An Coimisiún Pleanála
64 Marlborough Street
Dublin 1
D01 V902

RE: Case Reference: 320916, 320095 and 320094

Applicant: Coolpowra Flexgen Limited

Development: BESS, GAS Plant and GIS Substation

Drawing file: MAPS 27-03-26 / CPA-HAL-MP-XX-DR-PL-1000 P10 Master Plan Layout New Access Road.pdf

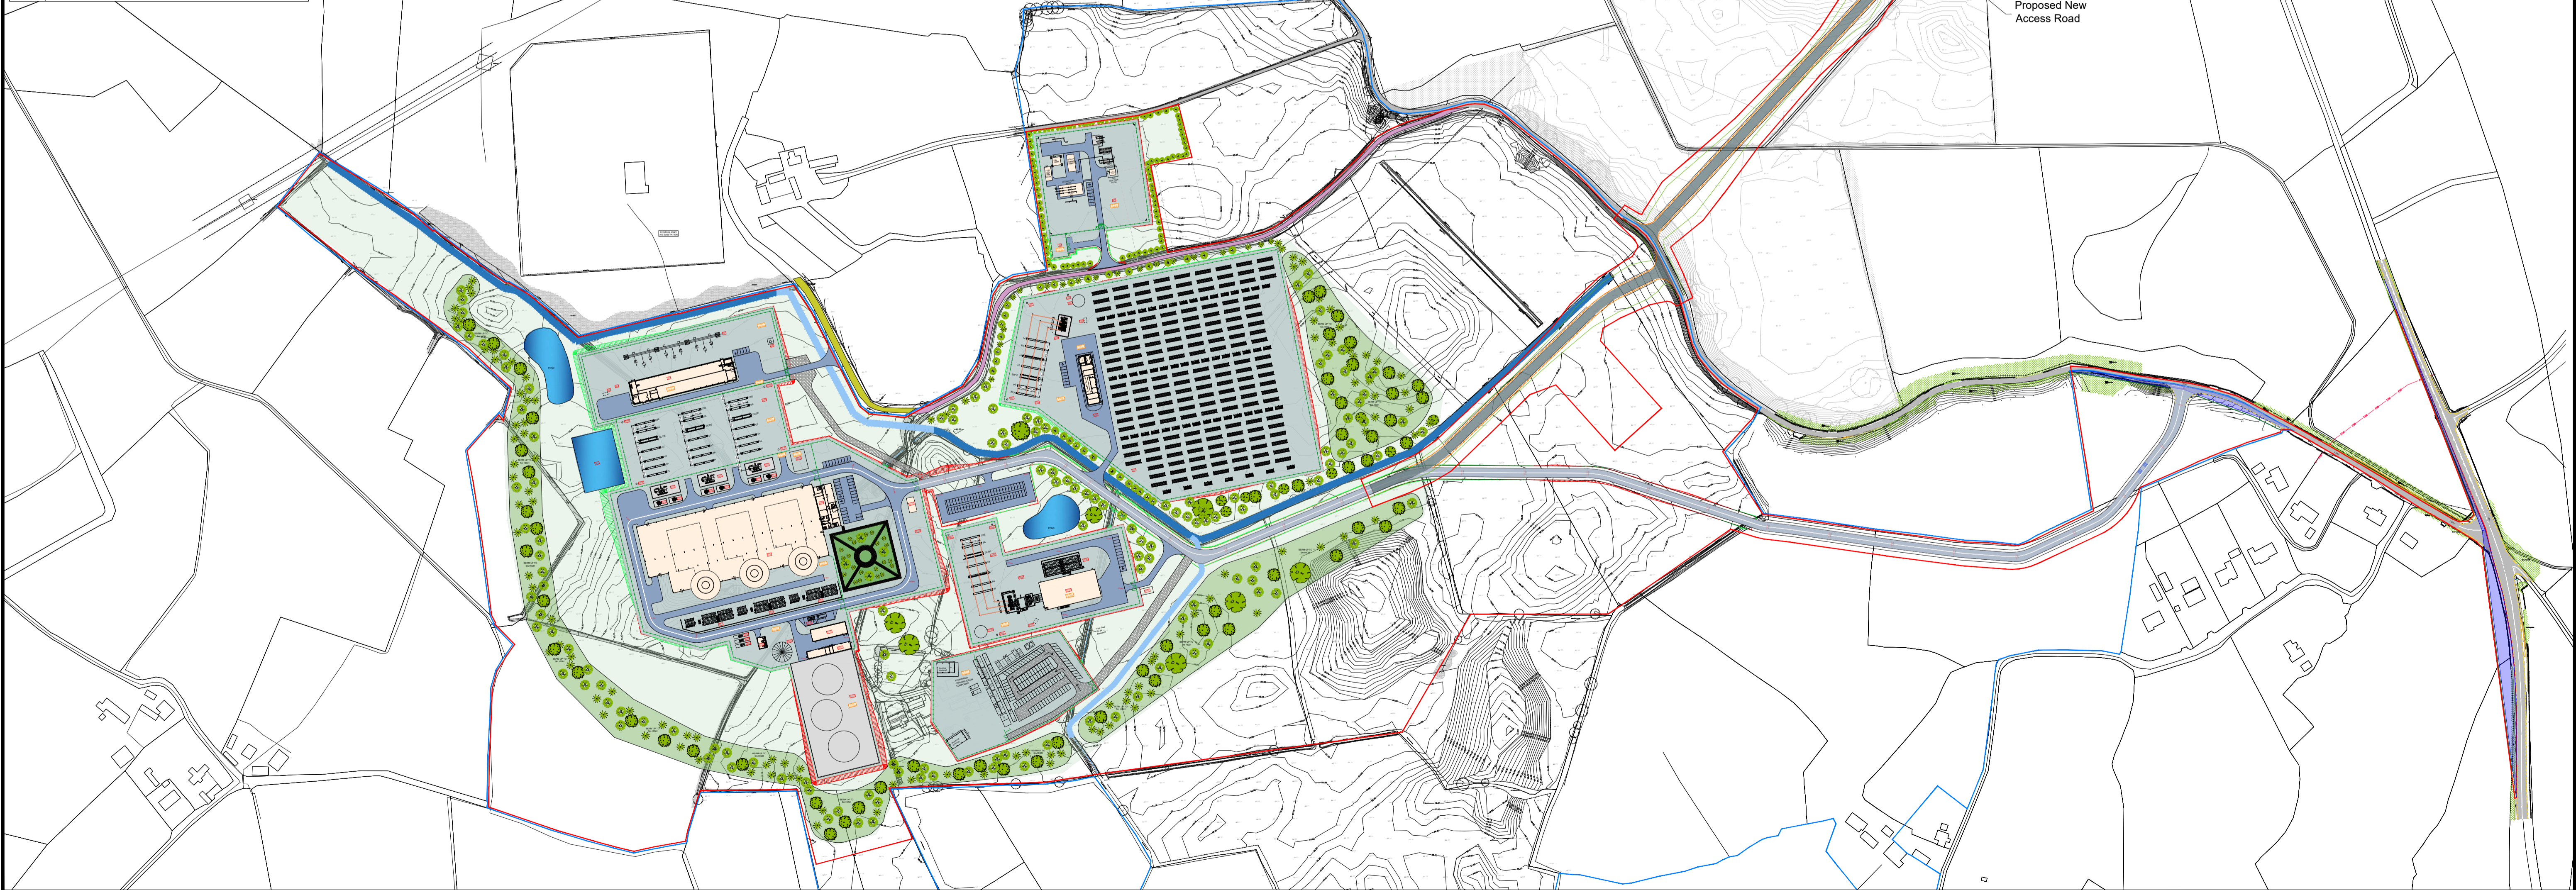
- **Deficient Sight Distances & Deficient Analysis:** The required safe sight distances depend on lands completely outside the applicant's legal ownership or control, making them unachievable. Furthermore, there's an unanalysed historical collision record for this stretch of road.
The proposed staggered road junctions on the L8763 will be a danger spot, won't have required sight lines. Large lorries turning out of one road, travelling few metres before then swinging into another entrance will cause oncoming local traffic to come to a standstill while they complete the manoeuvre.

- **Galway County Council** refusal stands as competent authority finding. They have refused application 320916 on grounds of 1) Traffic hazard, the construction of a whole new adjoining road does not remedy this. And 2) Appropriate assessment...also unremedied.

- **Redirection of Treananearla stream:** redirecting a small section does not avoid that fact that the majority of this stream will still travelling through the centre of this large scale site, in particular closely bordering 2 sides of the BESS. Should there be a fire at the battery facility (which is not uncommon in Ireland eg Claregalway) the stream will be directly hit.
